Online Comment

Application H23-0864-25
Location Oak Lodge Saltney Gate Saracens Head PE12 8AT
Proposal Proposed New Dwelling including the demolition of existing domestic workshop

Name Whaplode Parish Council
Address 48 Casswell Drive Quadring SPALDING PE11 4QW

Date Submitted 05-10-25
For/Against Comments

Proposed New Dwelling Oak Lodge, Saltney Gate Saracens Head, Holbeach For Mr M Hayes	Date November 2024	Drawn by RS Checked by
Sketch Scheme Plans, Sections and Elevations Site and Location Plans	Drawing Title Job No. SE-2213	Sheet Size A1 Dwg No. SS1000 Revision

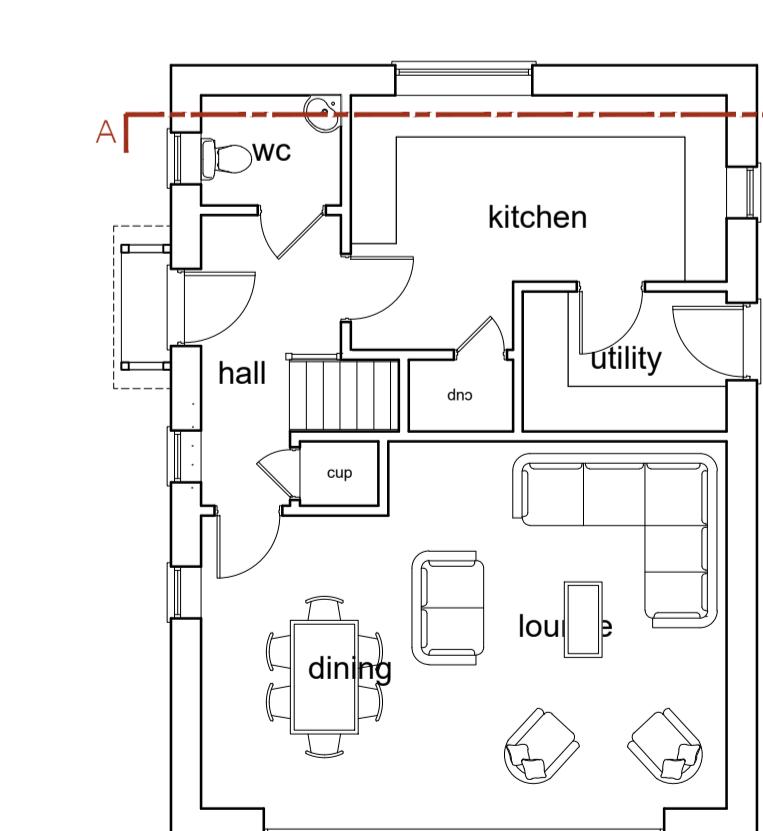
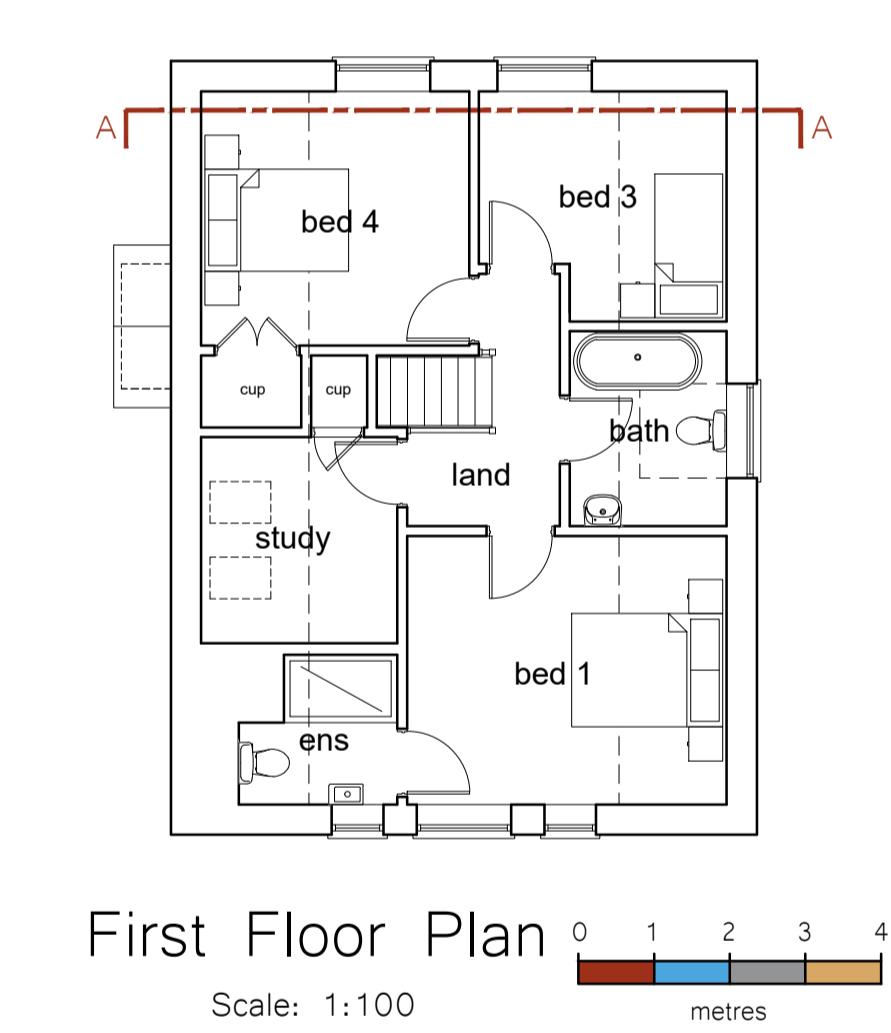
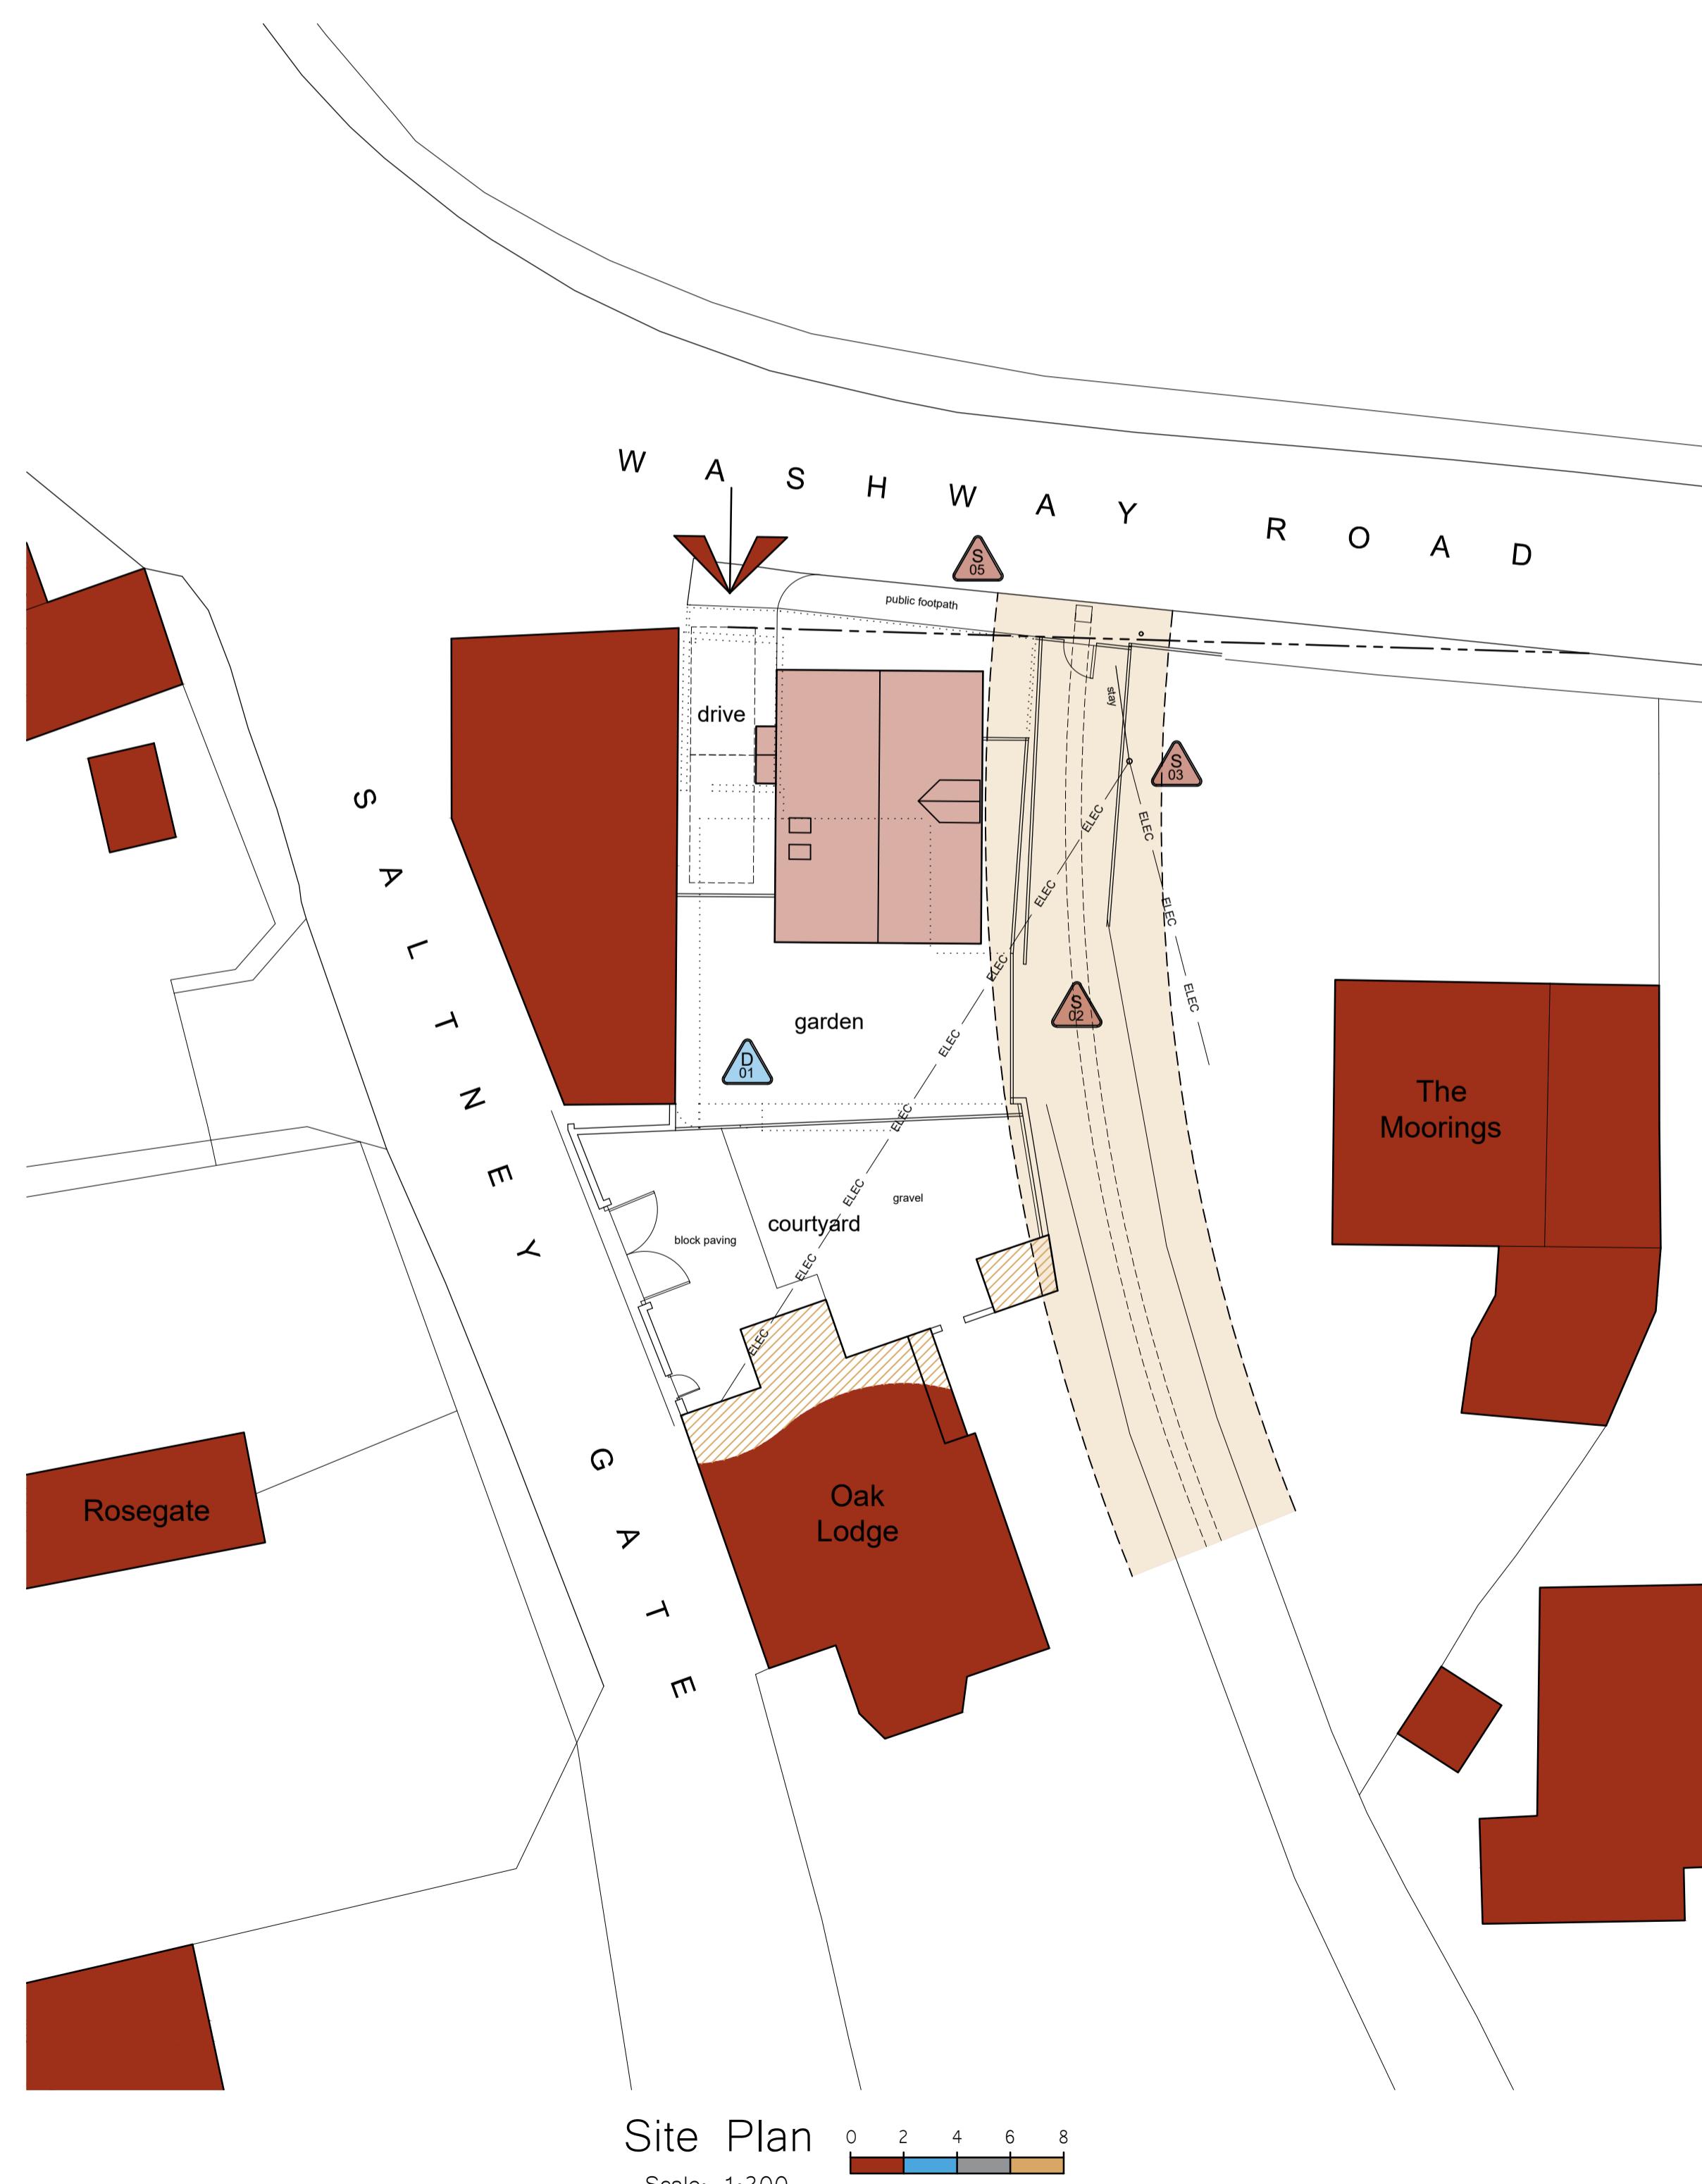
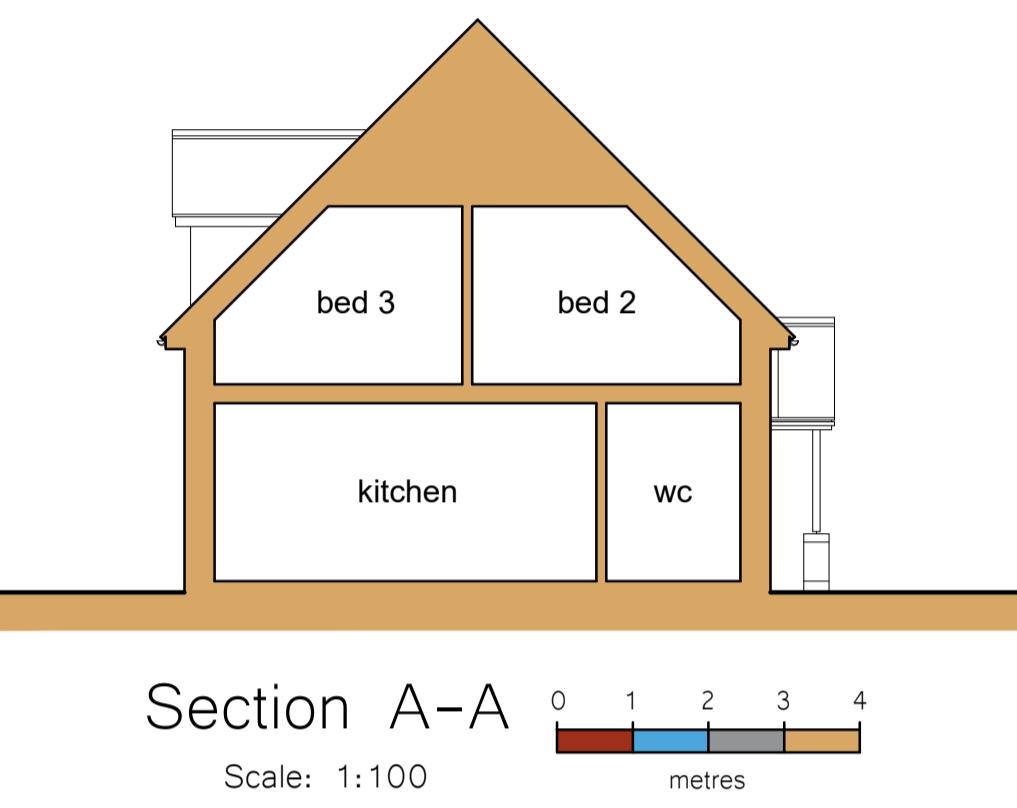
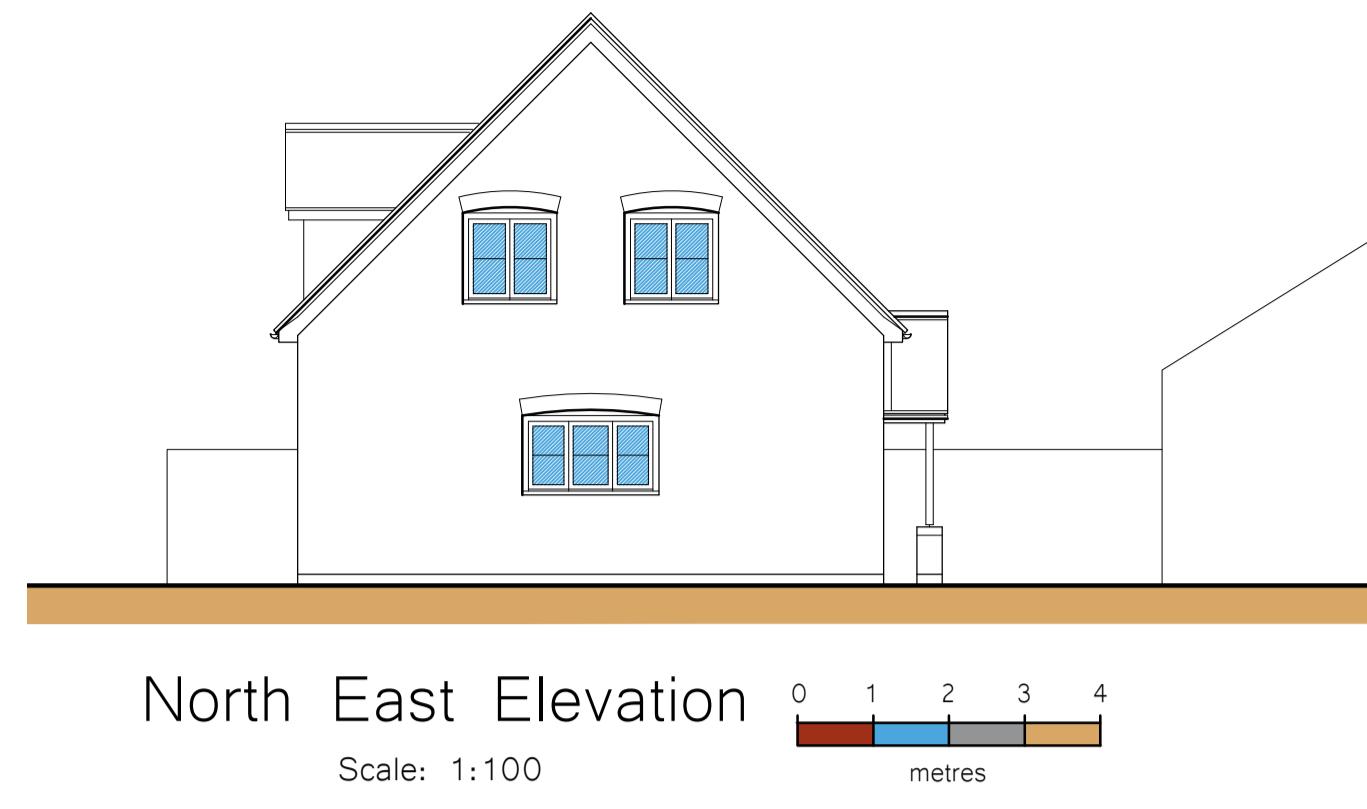
Further to our previous comments, there are other fundamental issues that need to be addressed, contamination, cramped form of development and close proximity to SHIDB piped culvert, does not comply with there bylaws.
